15 Michel Grove
East Preston
West Sussex
BN16 2SX

Planning Application EP/47/19/HH

PROPOSED FLOOR PLANS

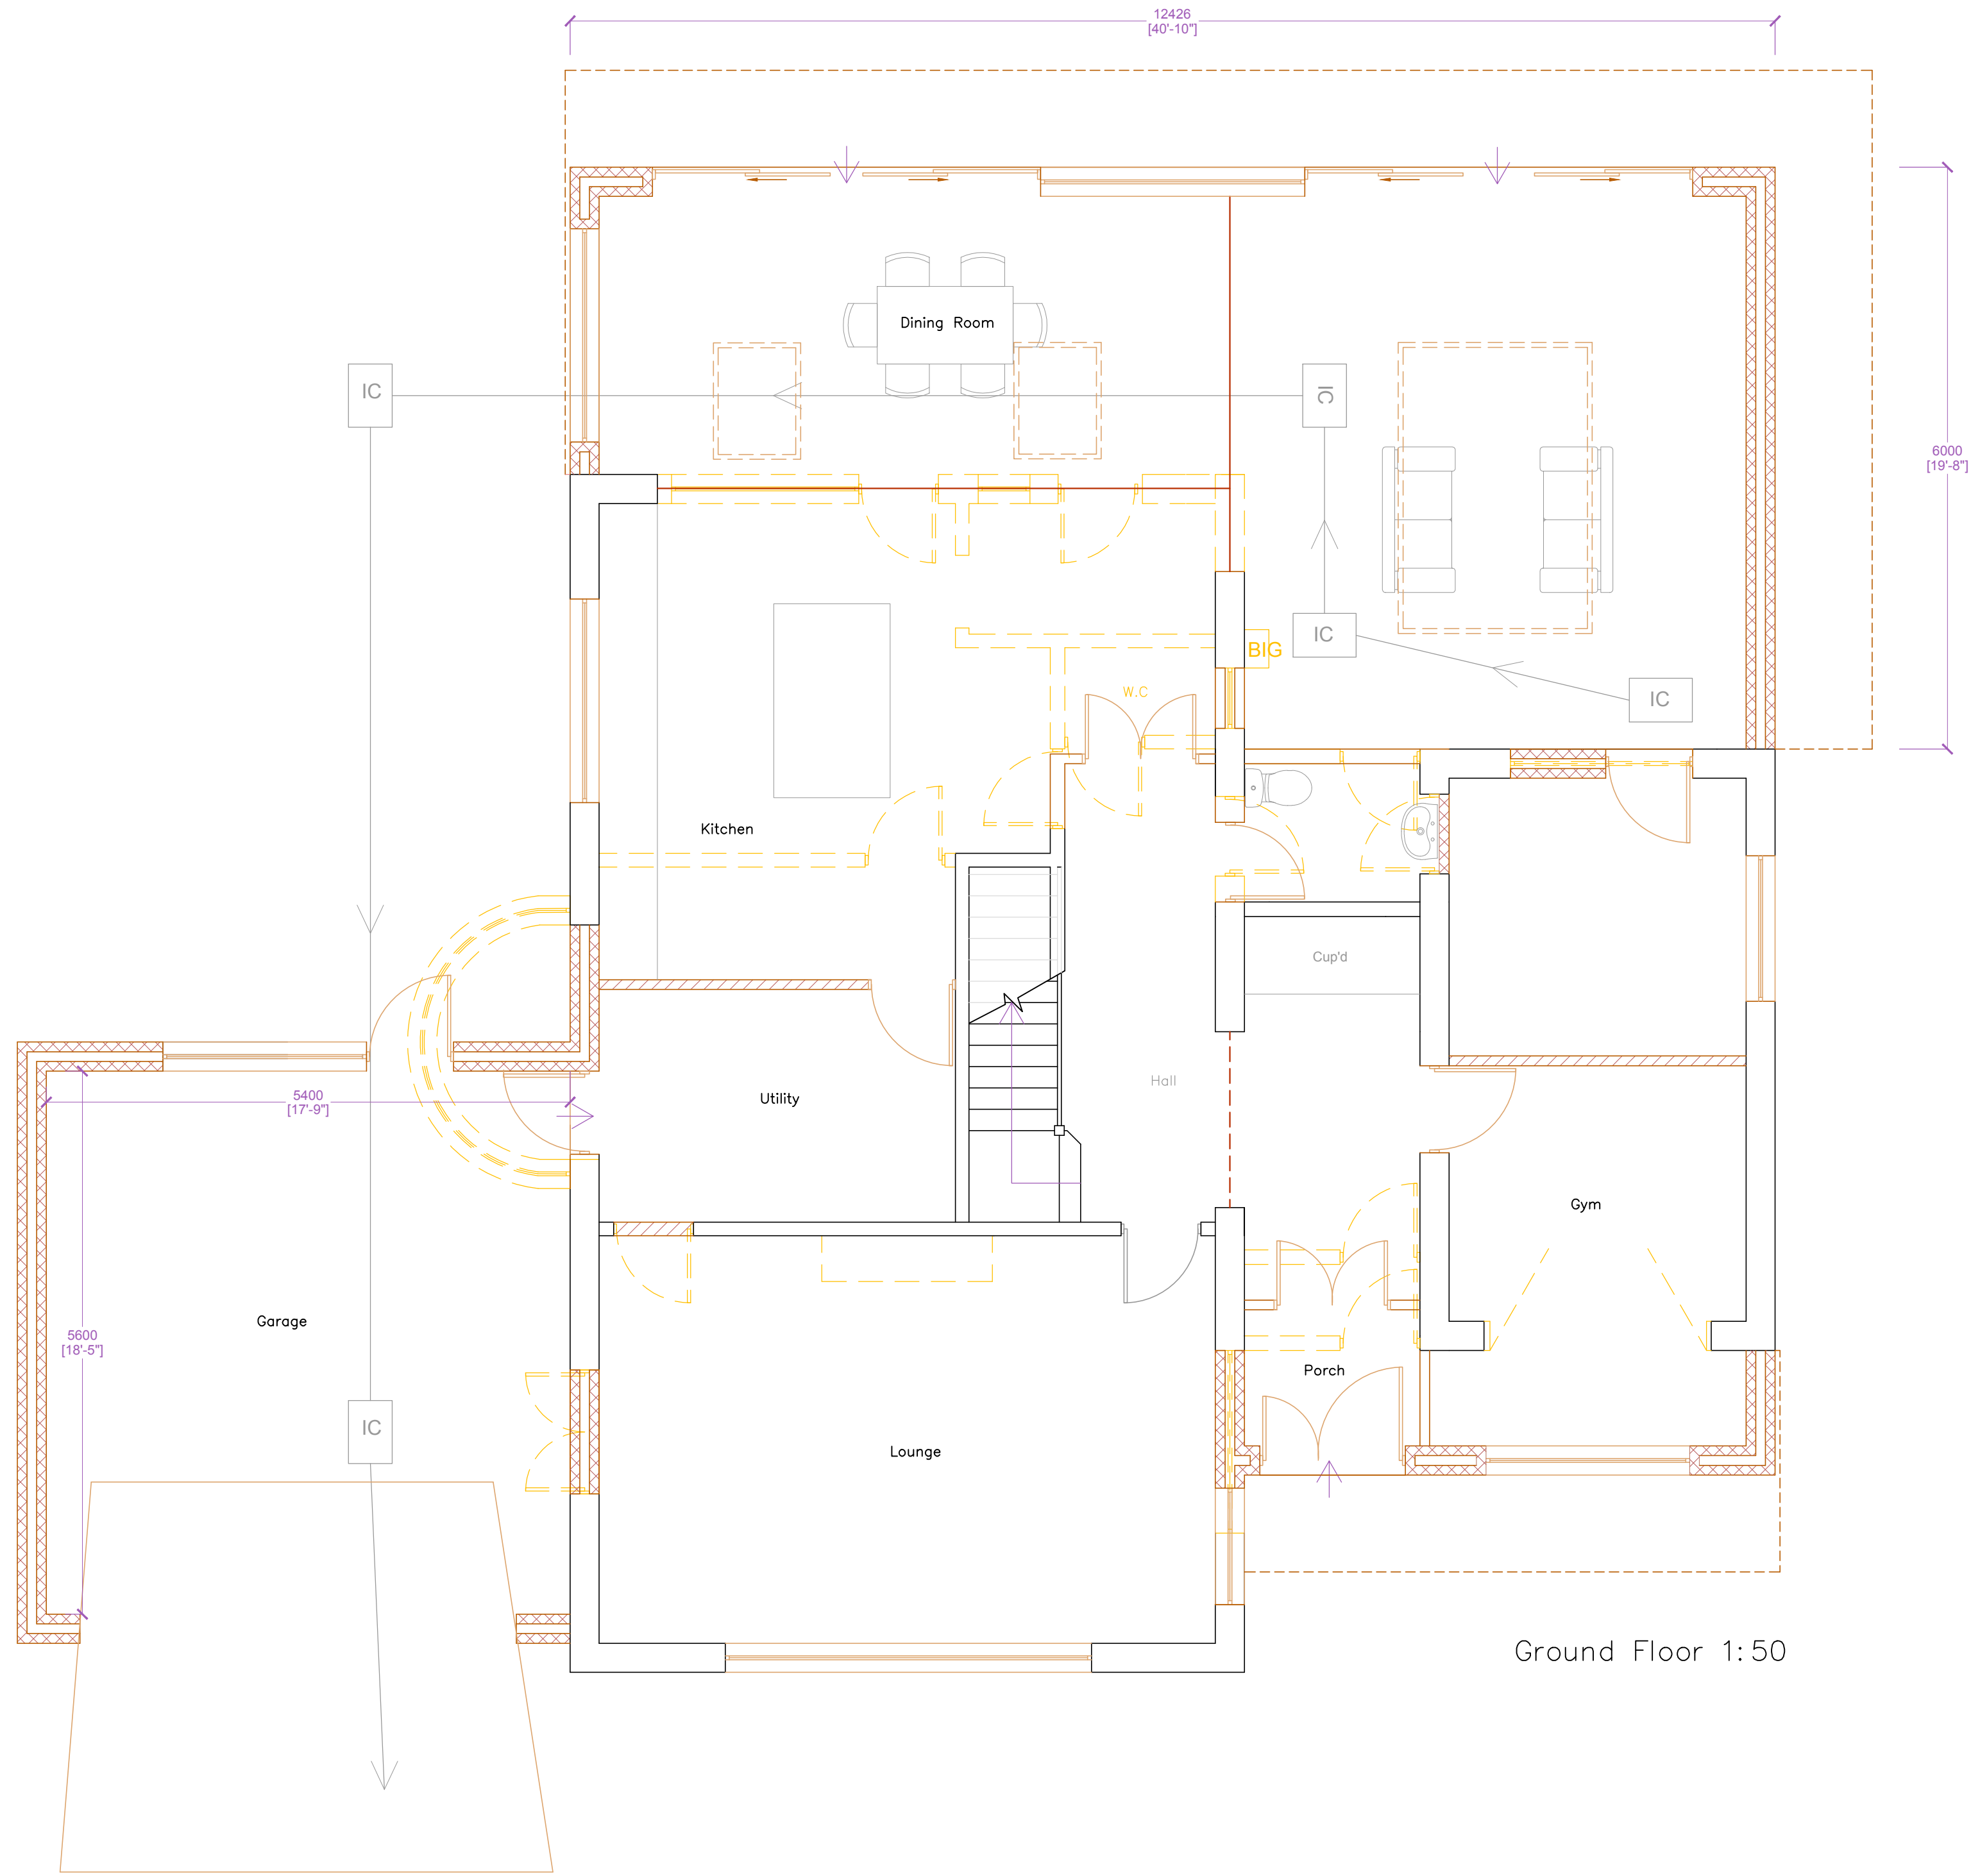
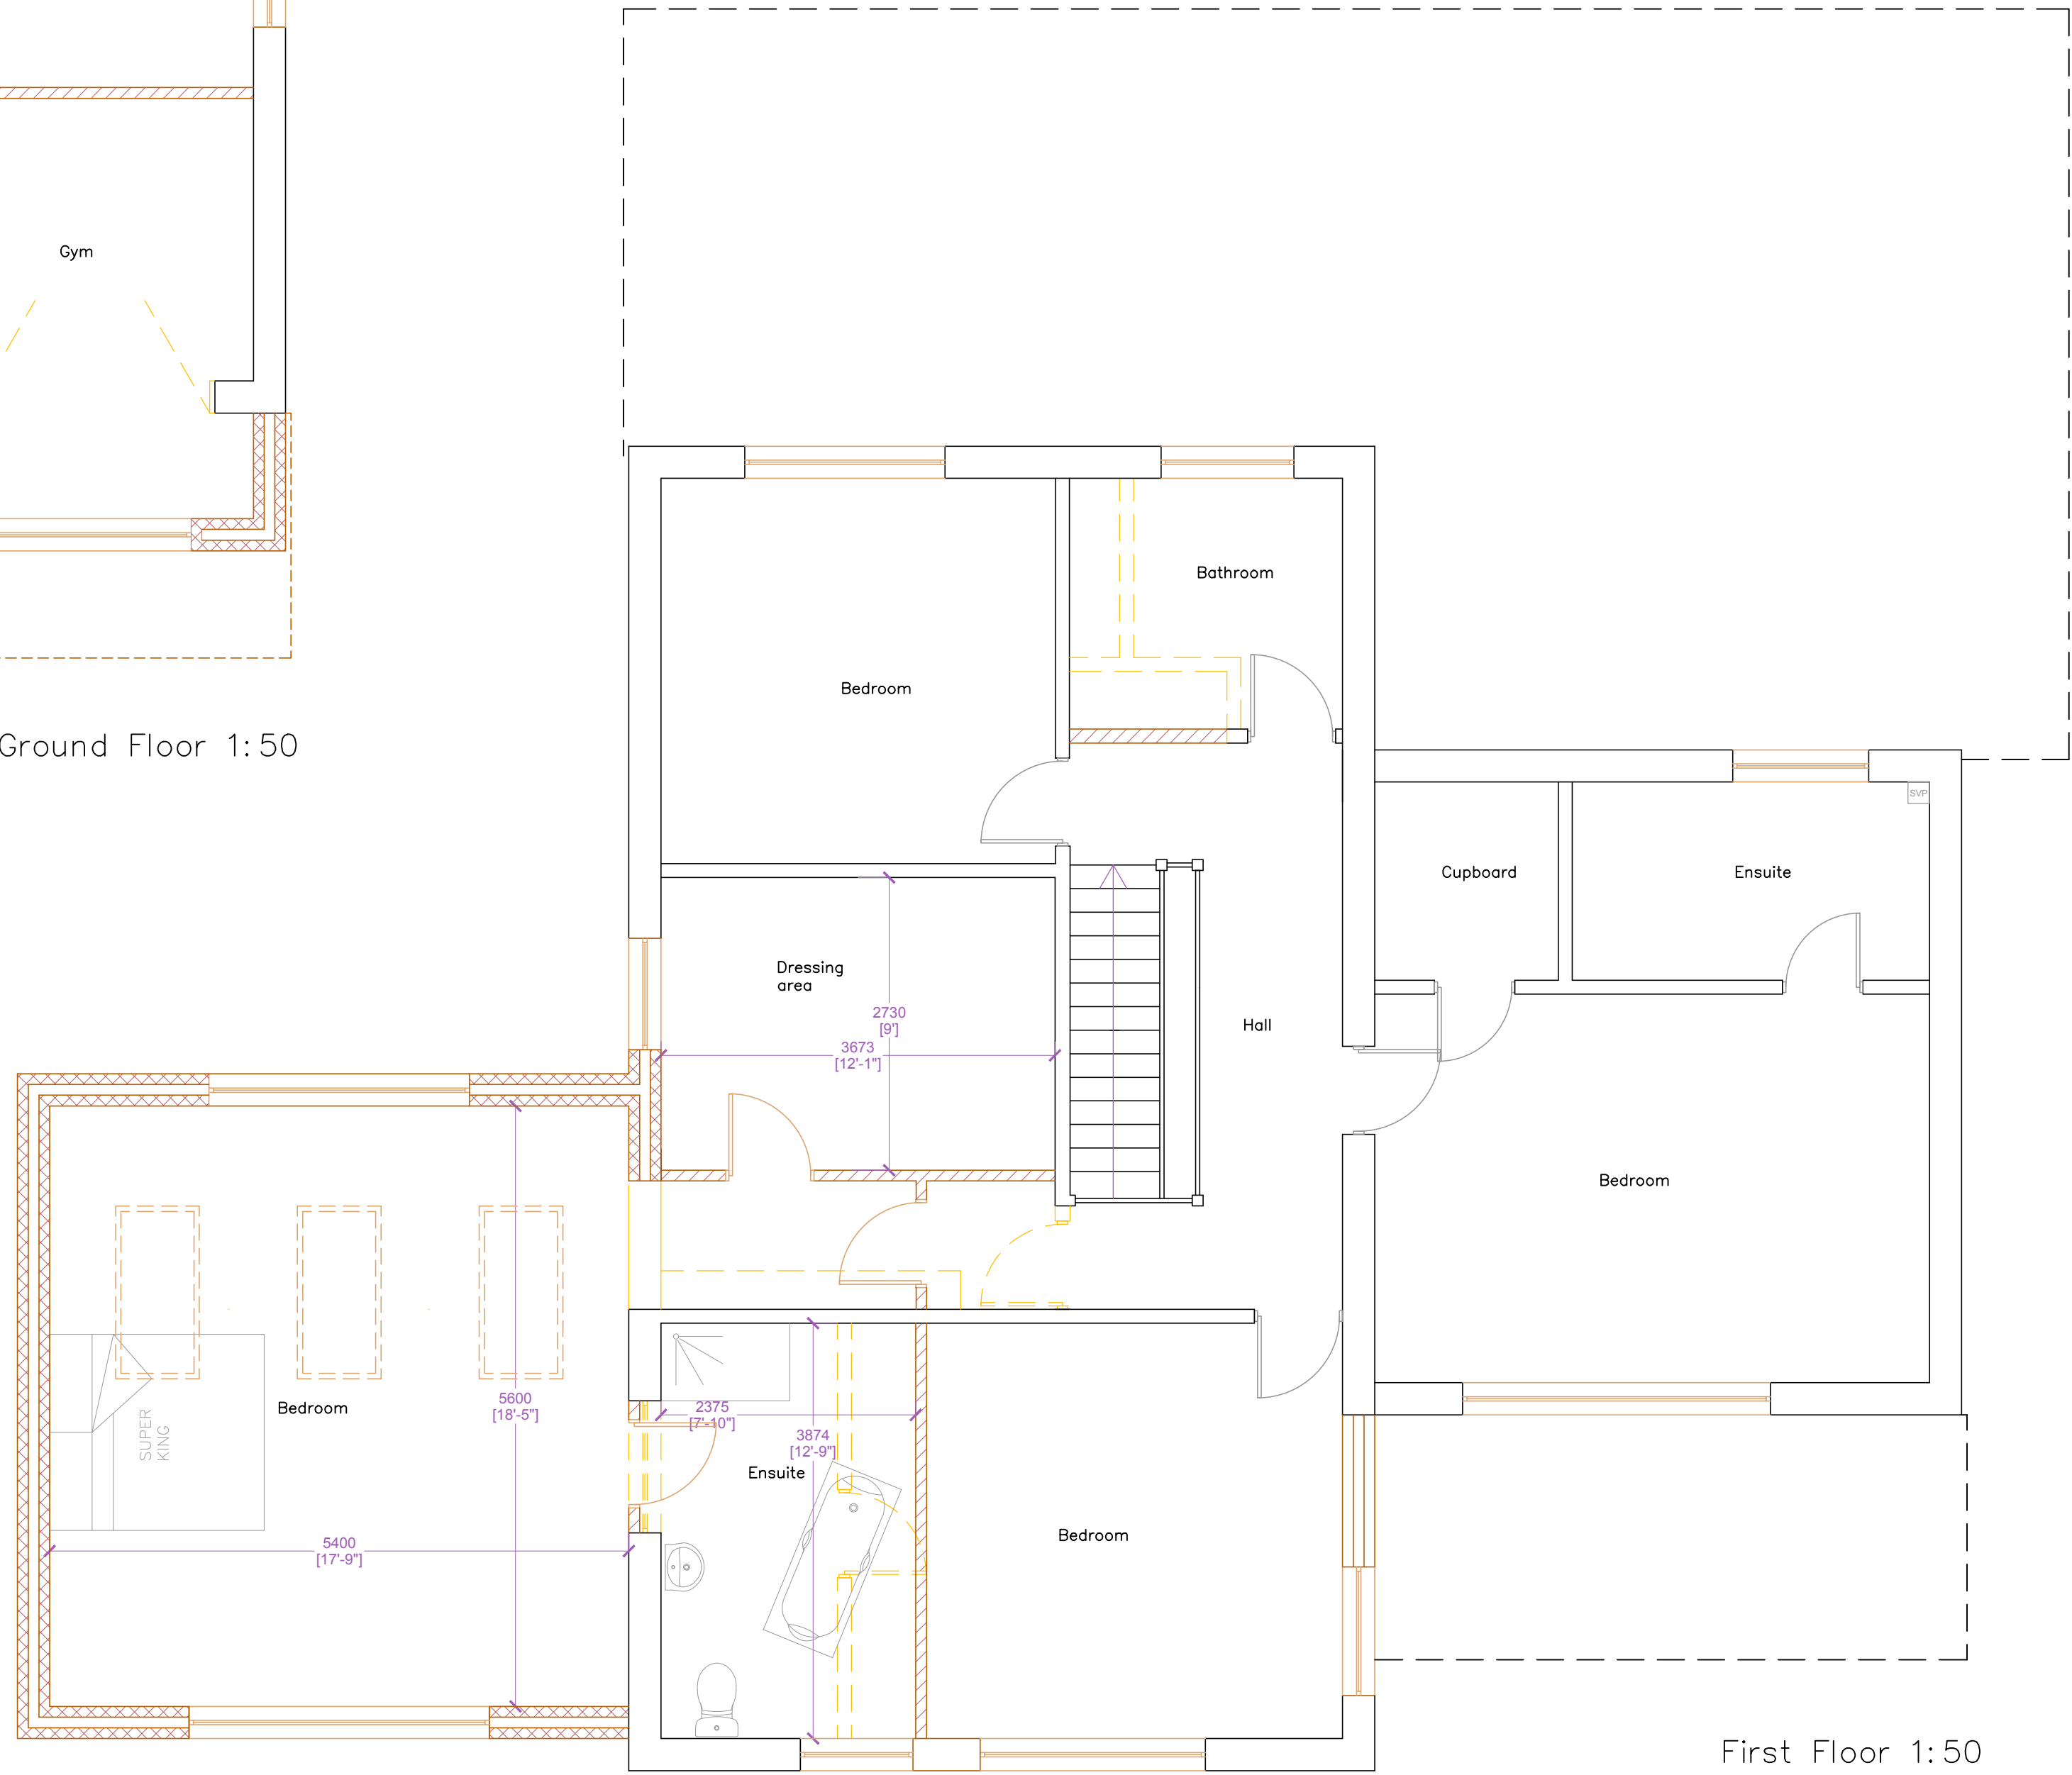
I think that you have been notified that development of the site changing it from a four bed roomed house into a six bed roomed house will quite contravene the East Preston Neighbourhood Development Plan.

Why do the two occupants now residing at 11 Michel Grove require six bedrooms? Do they intend setting up a nursing home or old peoples home which is quite out of the question for this Private Estate.
